17 April 2019

Town & Country Planning Act 1990 (as amended)
Town and Country Planning (Development Management Procedure) (England) Order 2015
Approval of details reserved by condition imposed under ref AB/99/18/L relating to Condition No 2
new joinery, Condition No 3 rainwater goods, Condition No 4 fire surround and Condition No 7
basement flooring.
44 Tarrant Street Arundel,,

This condition is discharged in so far as submission of details relates and refers to the agent's e-mail dated 05-04-2019 and drawing numbers H1.1 and FR1.1.

Drawing No: FR1.1

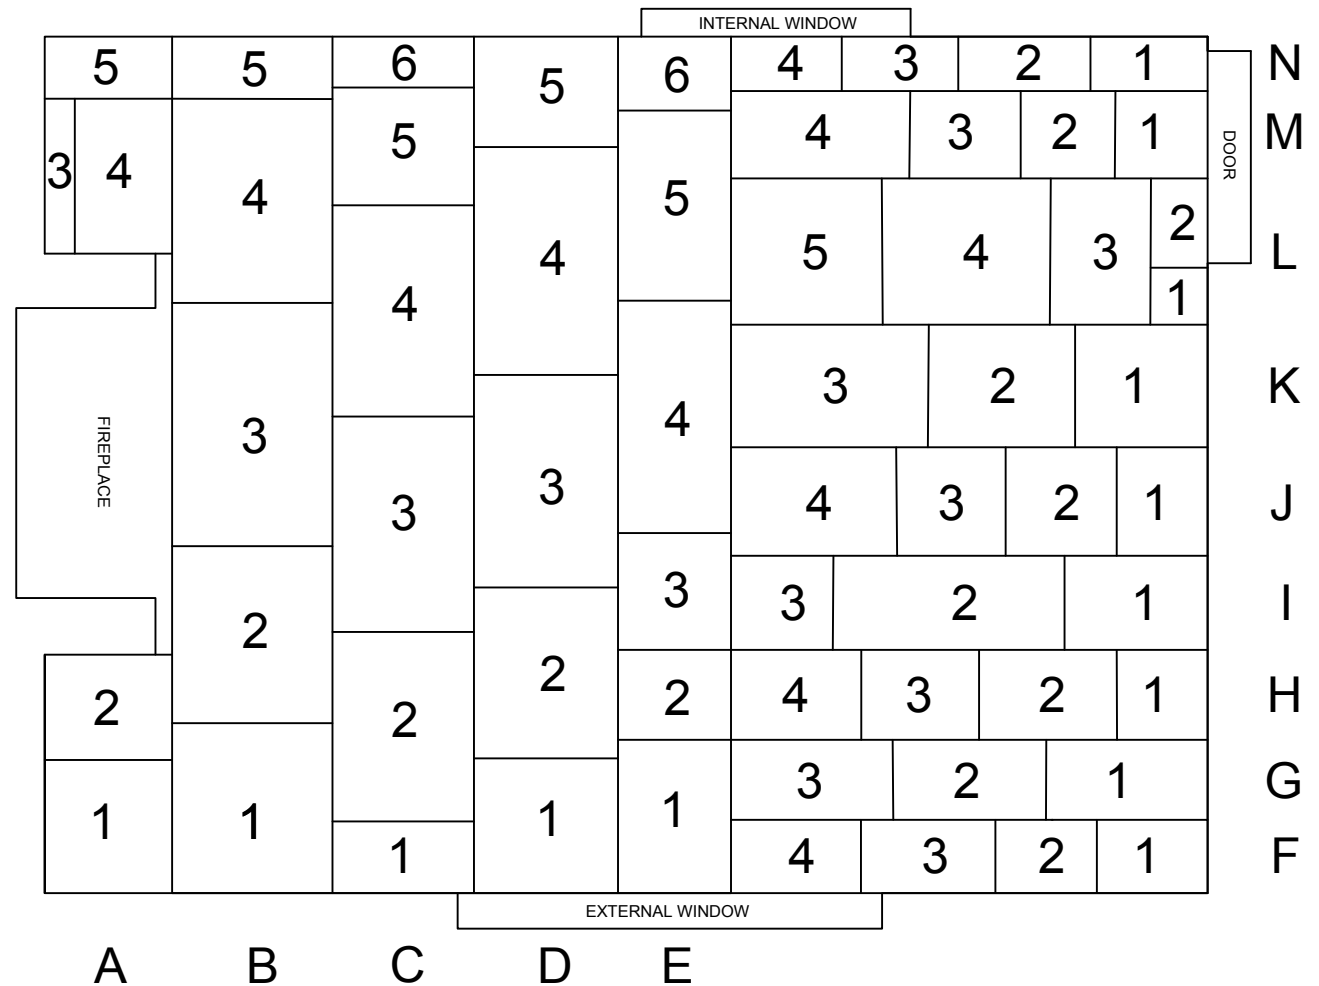
Prior to any works to the basement flooring commencing a methodology for its re-laying, to include a recording of the floor prior to the works, how it is to be removed, stored and re-laid shall be submitted to and approved by the Local Planning Authority before work to the basement floor is commenced and the works shall proceed in accordance with the details so approved.

Arun District Council have decided to **APPROVE details reserved by this condition**
